Our Ref: AB/73/18/PL

**Town & Country Planning Act 1990 (as amended)
Town and Country Planning (Development Management Procedure) (England) Order 2015
Application for Planning Permission**

Development	Demolition of garage & erection of two dwellings with associated car parking and landscaping
Location	18 Queens Lane Arundel

FIRST FLOOR PLAN - PROPOSED
SCALE 1:100
Scale in Metres
0 1 2 3 4 5 10

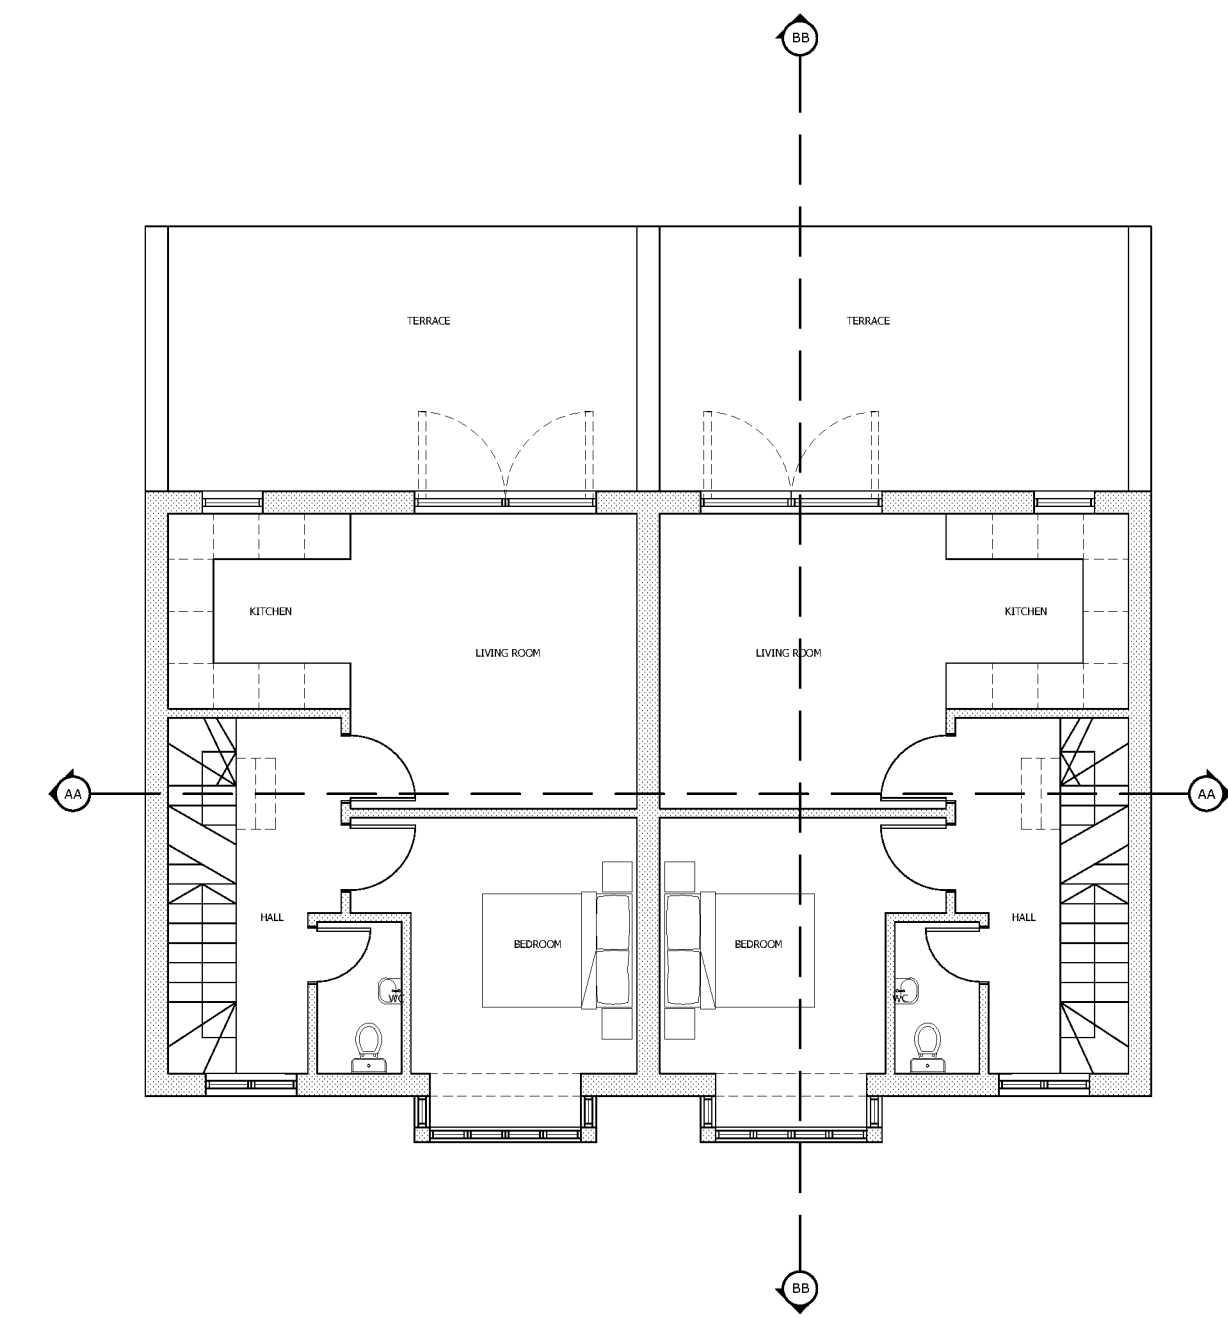
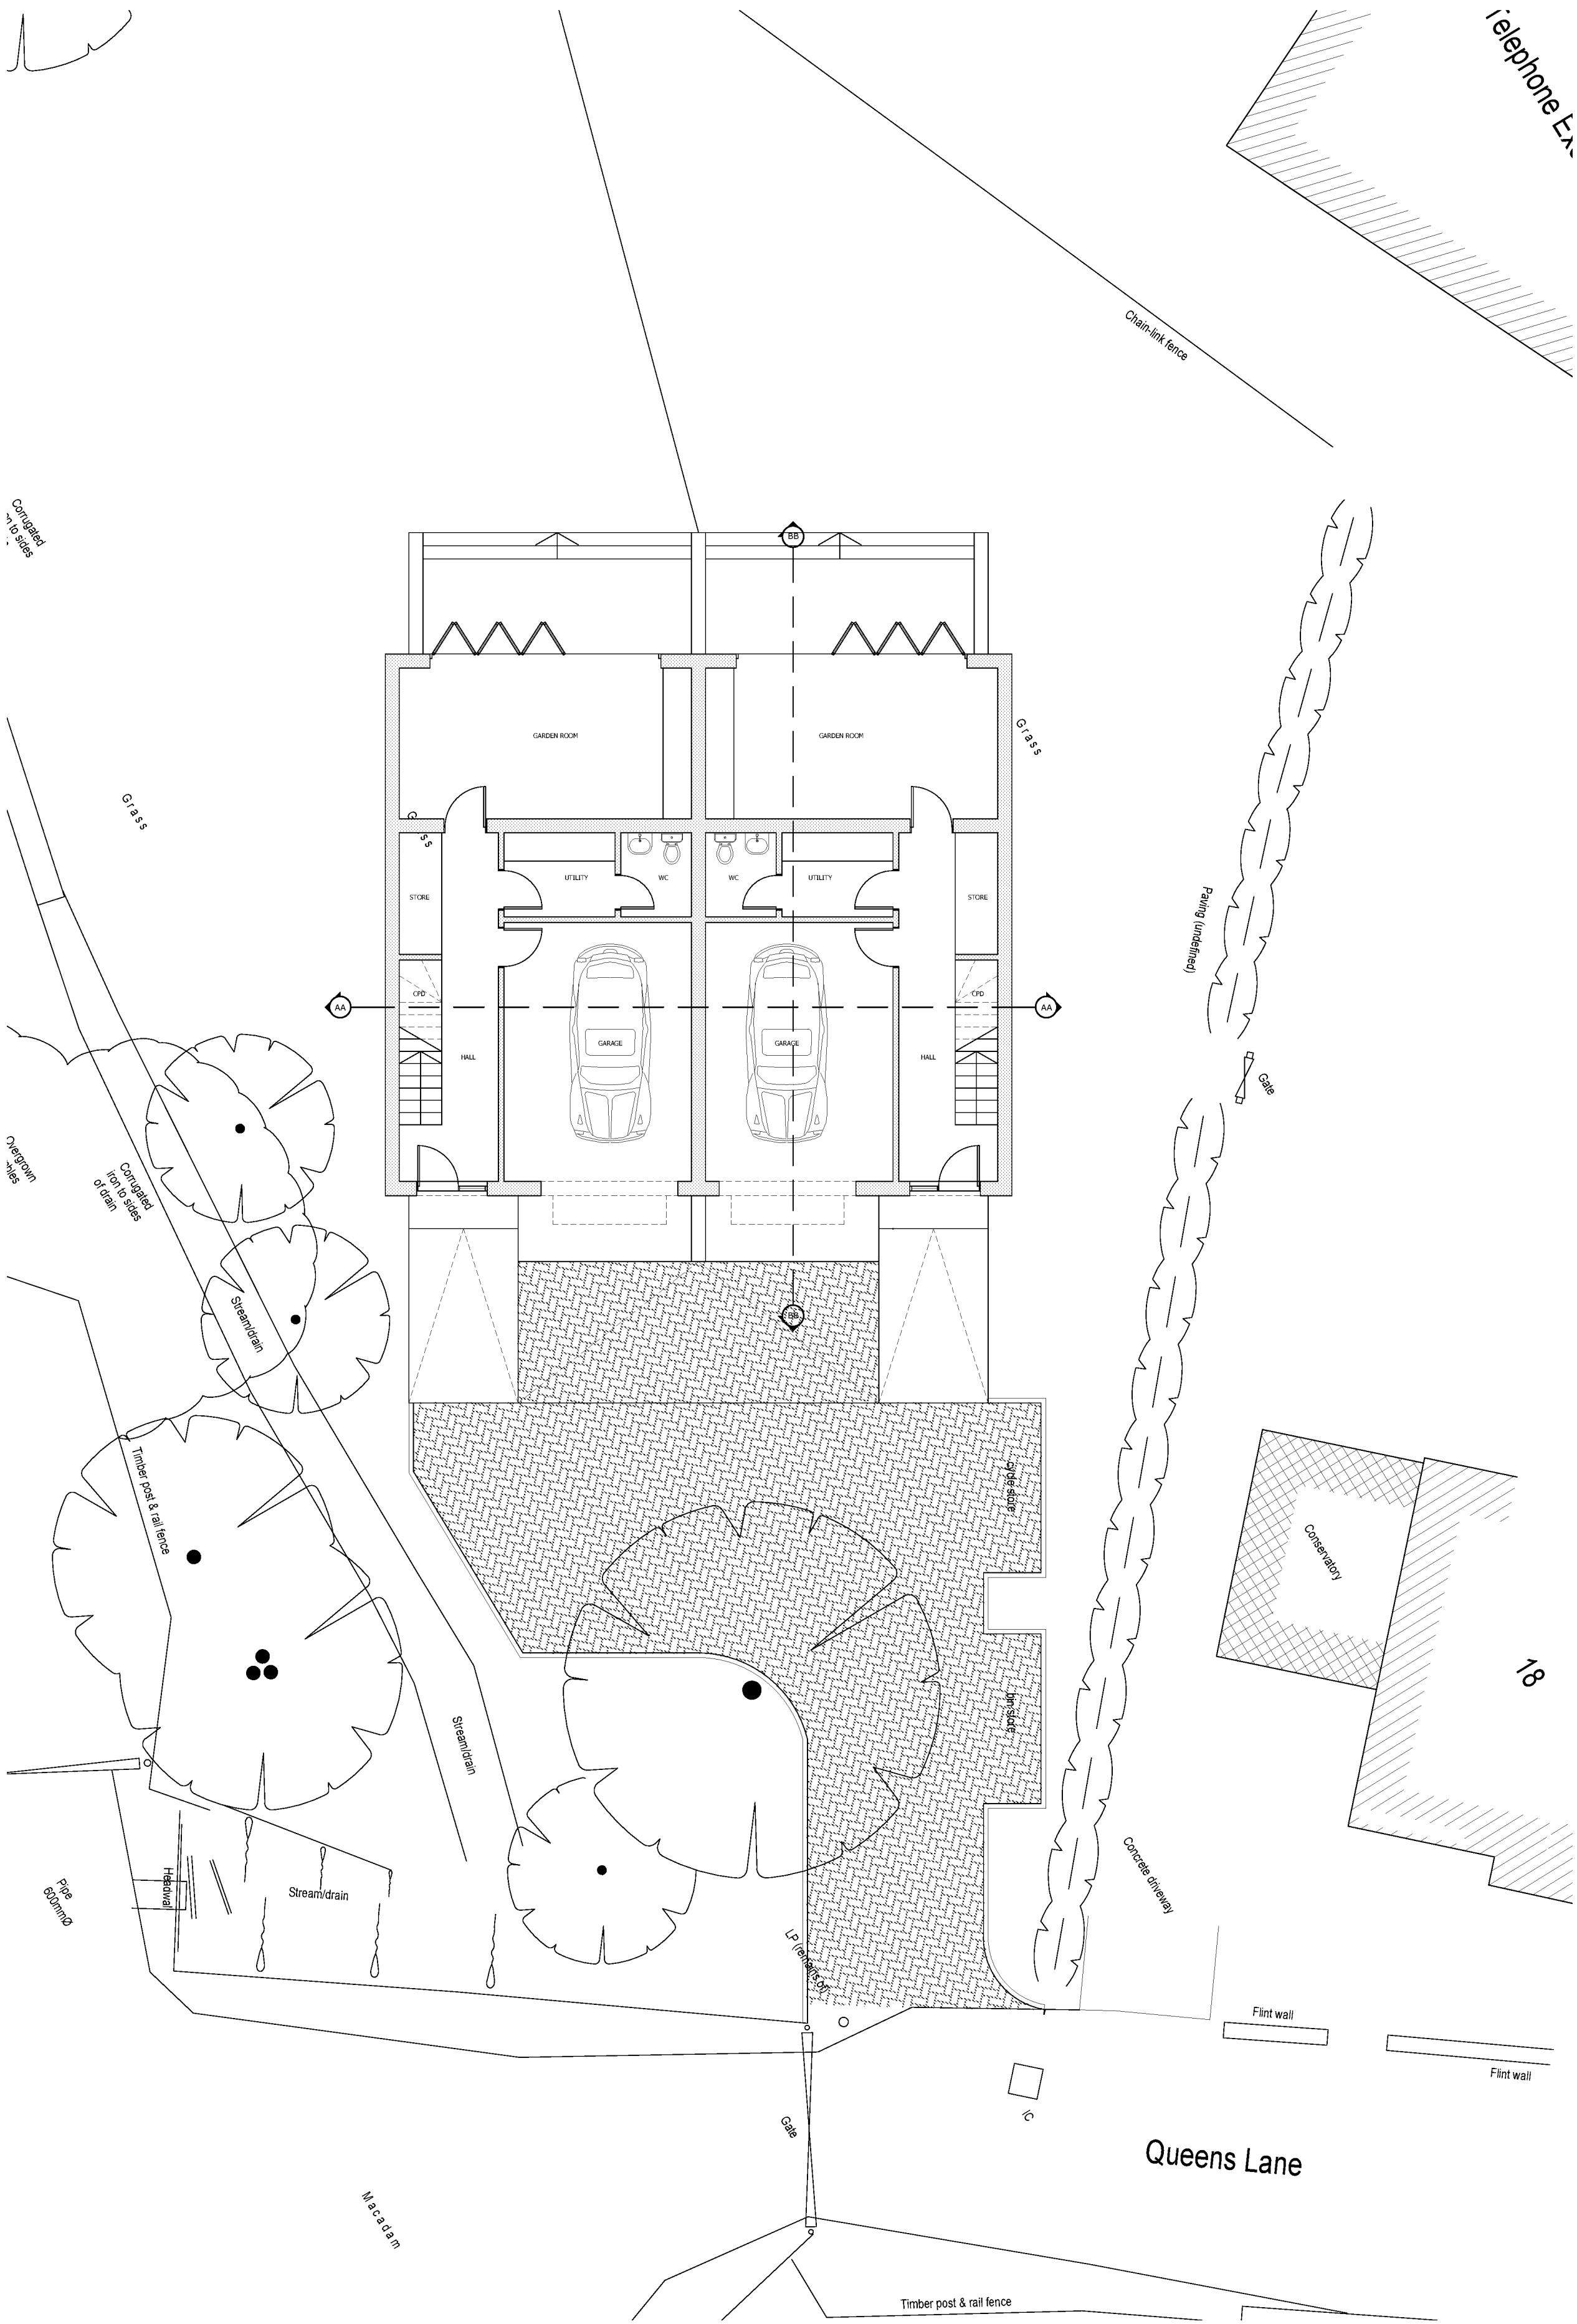
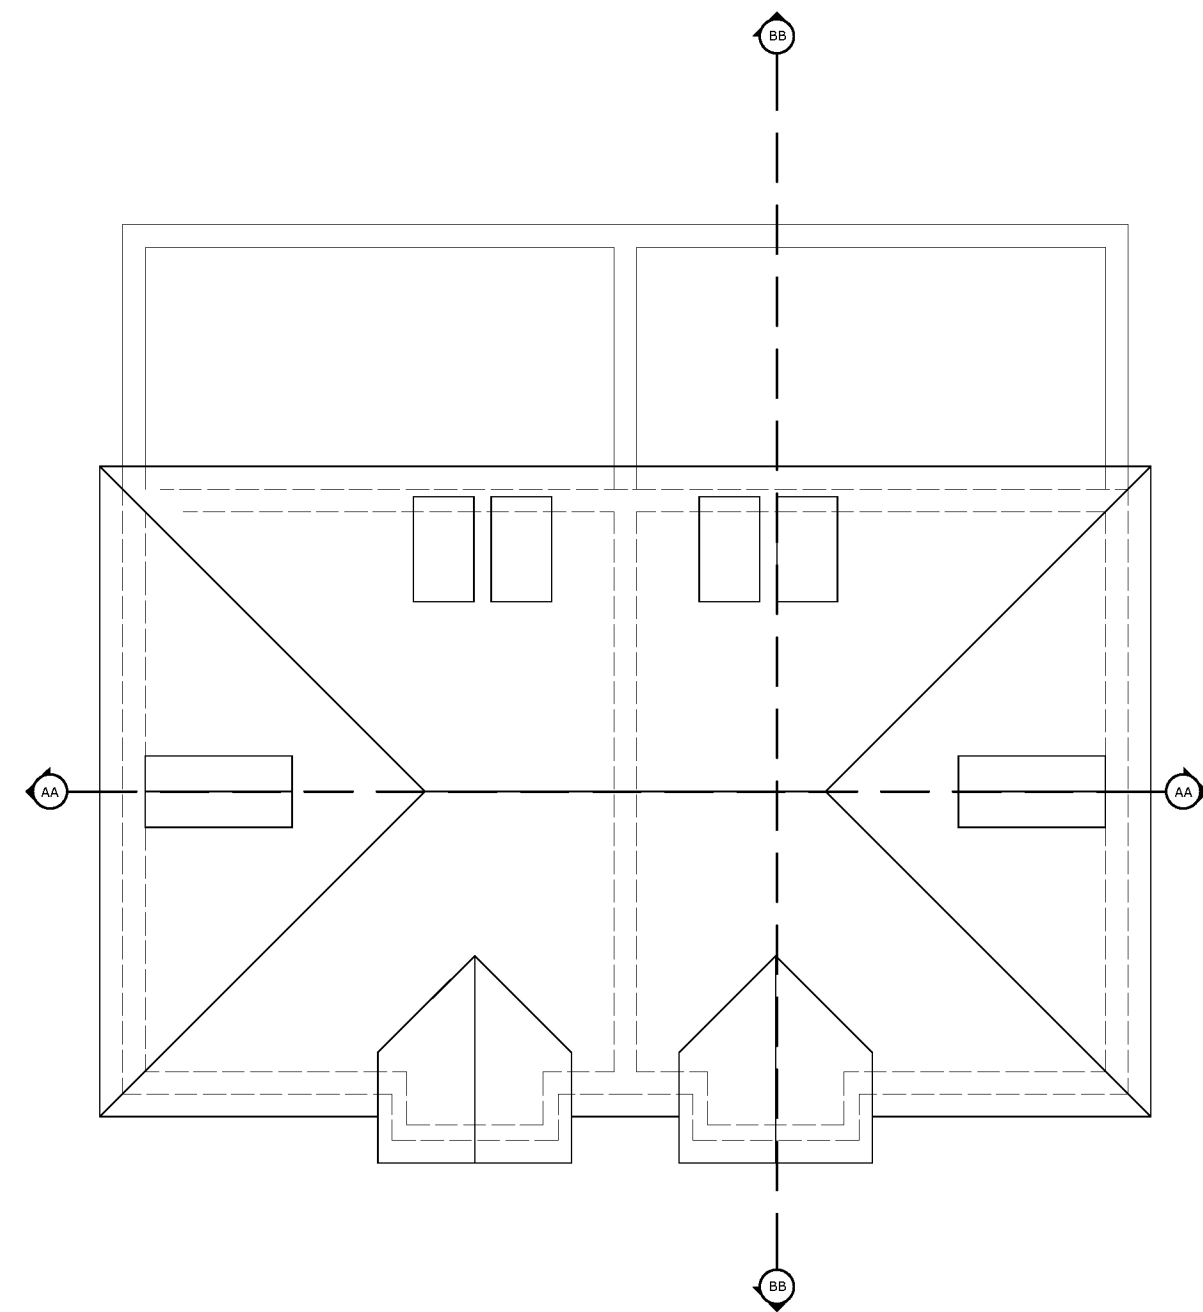
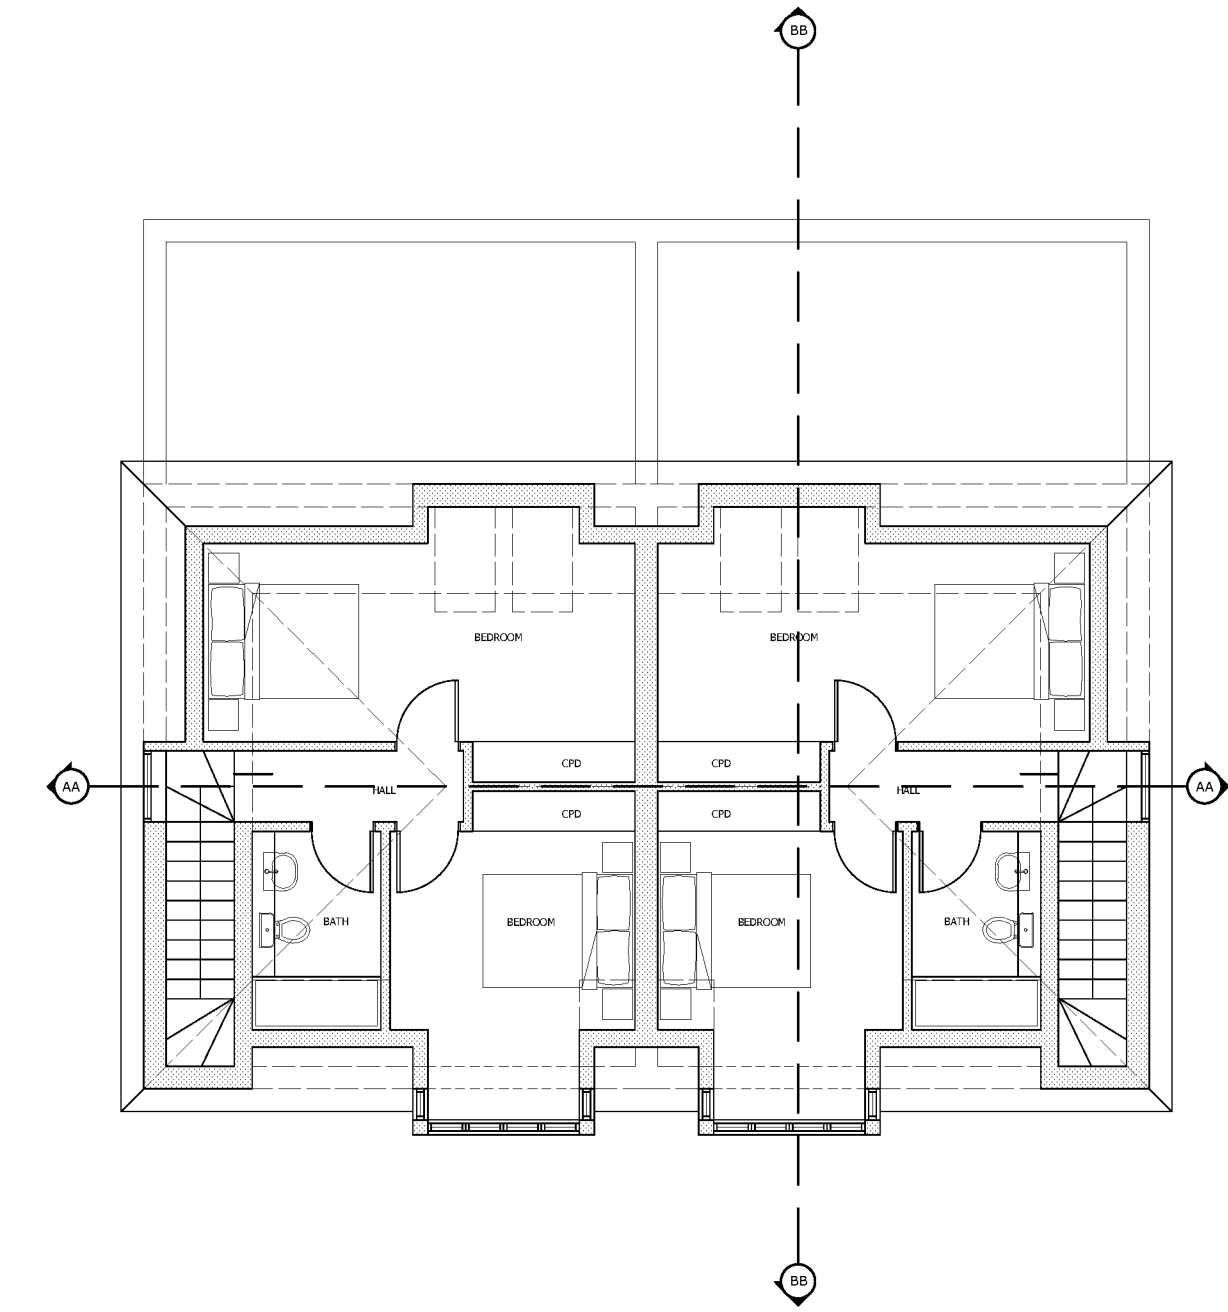
There are small windows indicated on the Proposed North and South elevation that have not been indicated on the proposed floor plans. Please amend accordingly.
